**Objection to Planning Application 3/2026/0153**  
**Proposal: Formation of a stone access track and improvements to an existing access**  
**Location: Land off B6478, Slaidburn**

**Objection to Planning Application: 3/2026/0153**  
**Proposal: Formation of a stone access track and improvements to an existing access**  
**Location: Land off B6478, Slaidburn**

Surface Water Flood Extent

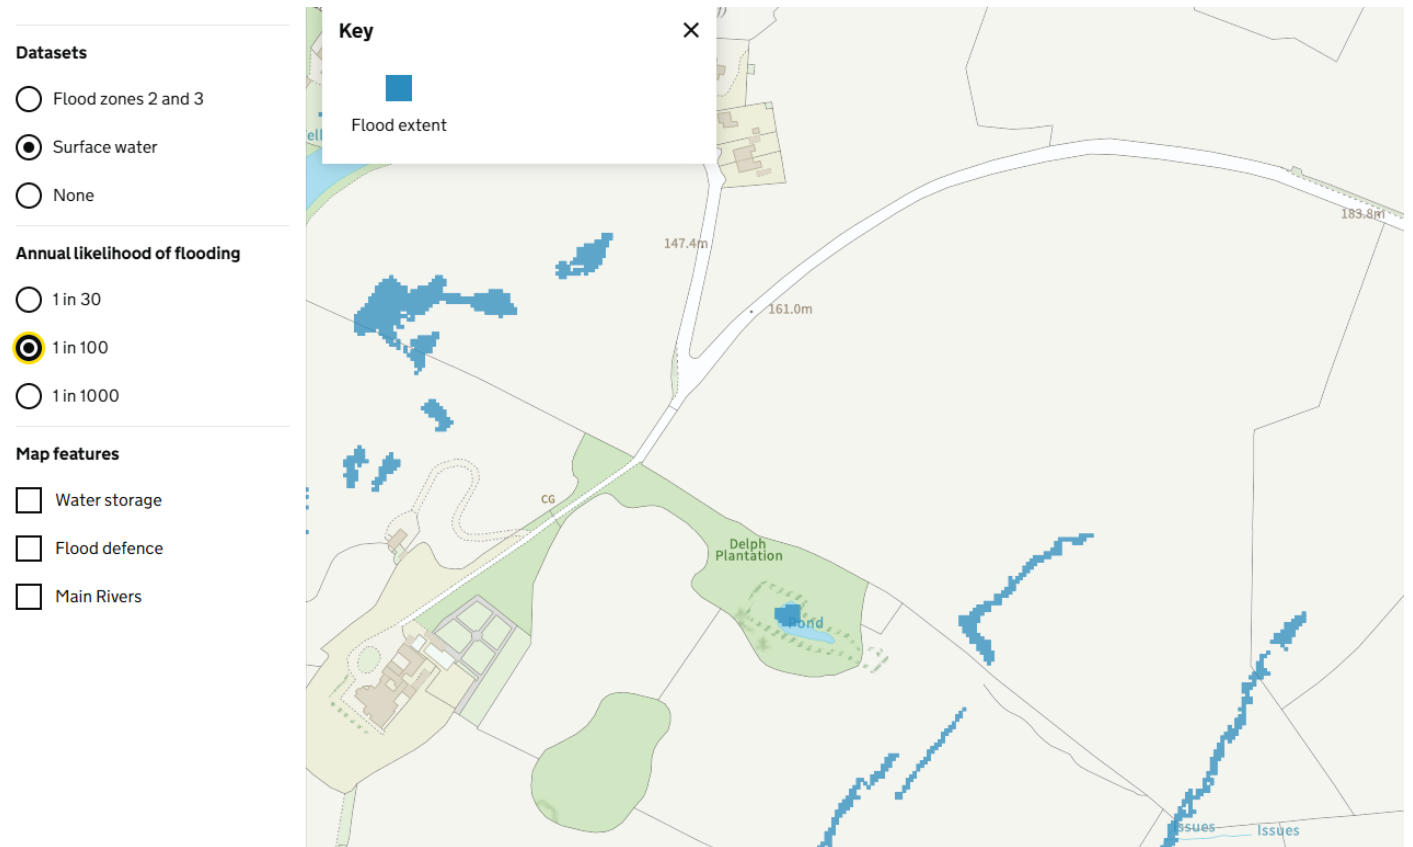
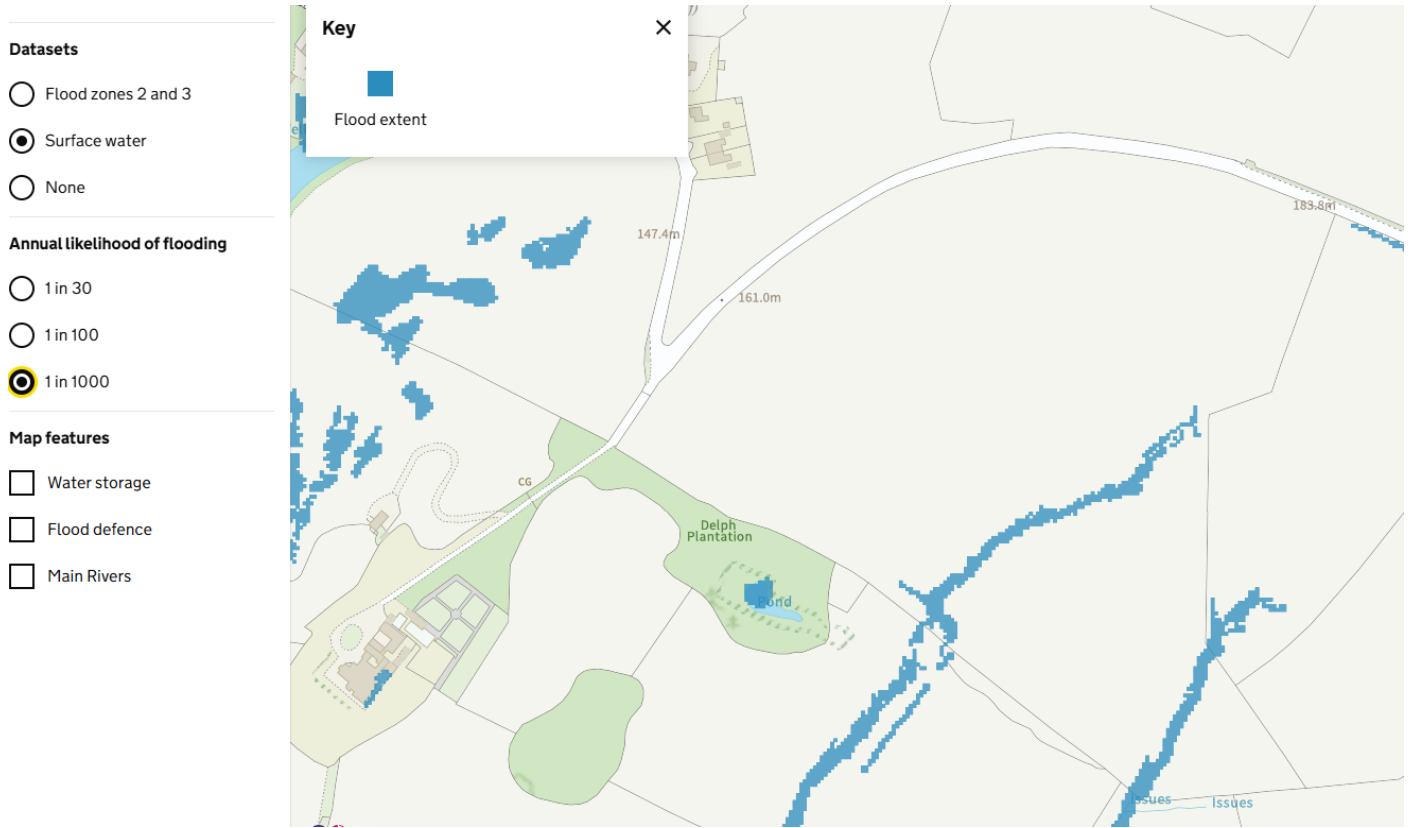
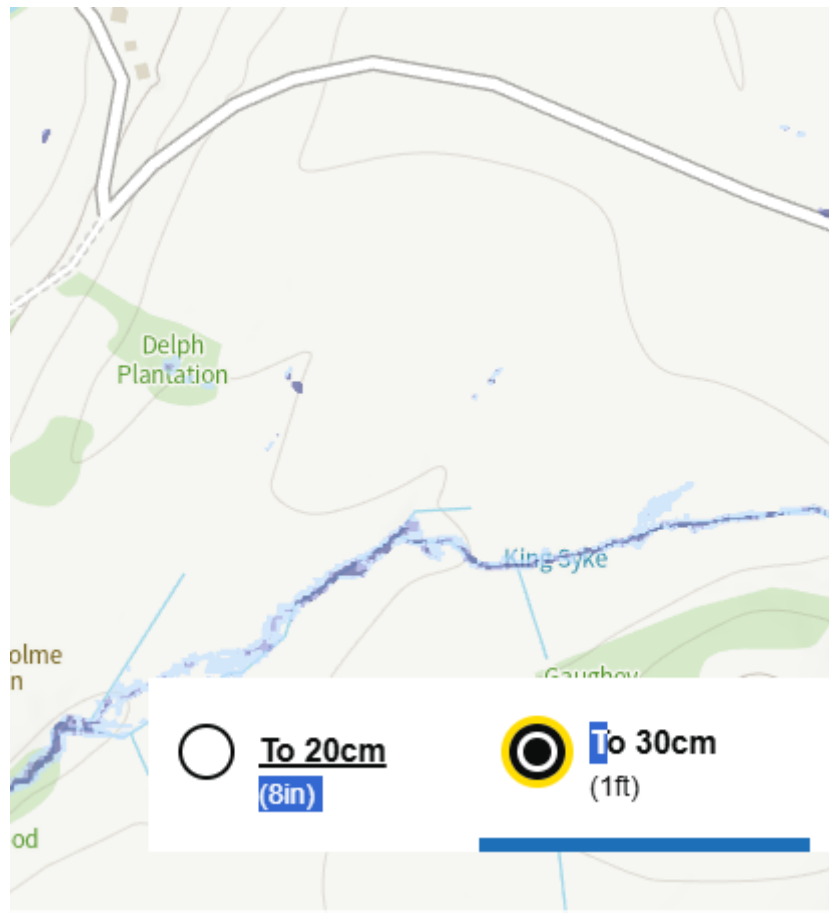
The Flood Risk Assessment acknowledges surface water flooding in multiple return periods. However:

No detailed surface water drainage strategy is provided  
No assessment of runoff impact from extensive new hard surfacing  
No consideration of off-site or downstream impacts

The conclusions dismiss flood risk on the basis of event duration rather than hydraulic consequence, which is inadequate for decision-making.
